SOPA has reviewed the documentation which accompanies MOD2 MP11_0082 and offers the following comments:

Proposed Samsung Service Centre

Business Identification Signage

Figure 3: Approved (top) and proposed (bottom) lower ground floor layout (Base source: proponent's application)

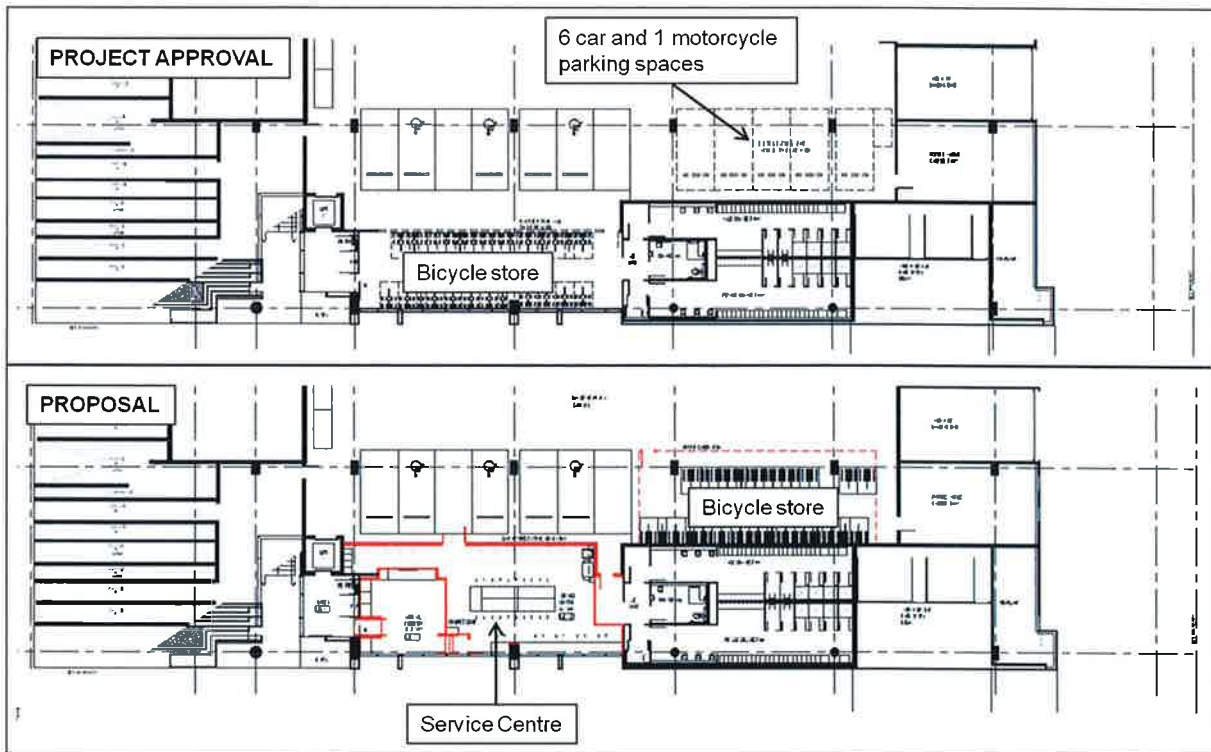
It is noted that this proposal necessitates the relocation of the bike storage room, which has a number of flow-on effects including:

- (i) the loss of 6 car parking spaces and 1 motorcycle space;
- (ii) a change to the access arrangements for cyclists, that is, access via the lobby is proposed to be deleted and therefore all cycle access will be via the car park ramp; and
- (iii) a net increase in GFA of 113.5m².

However there is some concern regarding the deletion of the cyclist access to the bicycle storage area via shuttle lift from the ground floor and access only now being achieved via the car park access ramp. This arrangement will increase the potential for cycle / vehicle conflict.

SOPA raises no objection to the altered access arrangement to the bicycle parking provided the gradient of the access ramp to the bicycle parking does not exceed 25%, as set out in Table 4: Design Principles and specifications for bicycle racks and hardware of the “*Planning guidelines for walking and cycling*”, DIPNR Dec 2004.
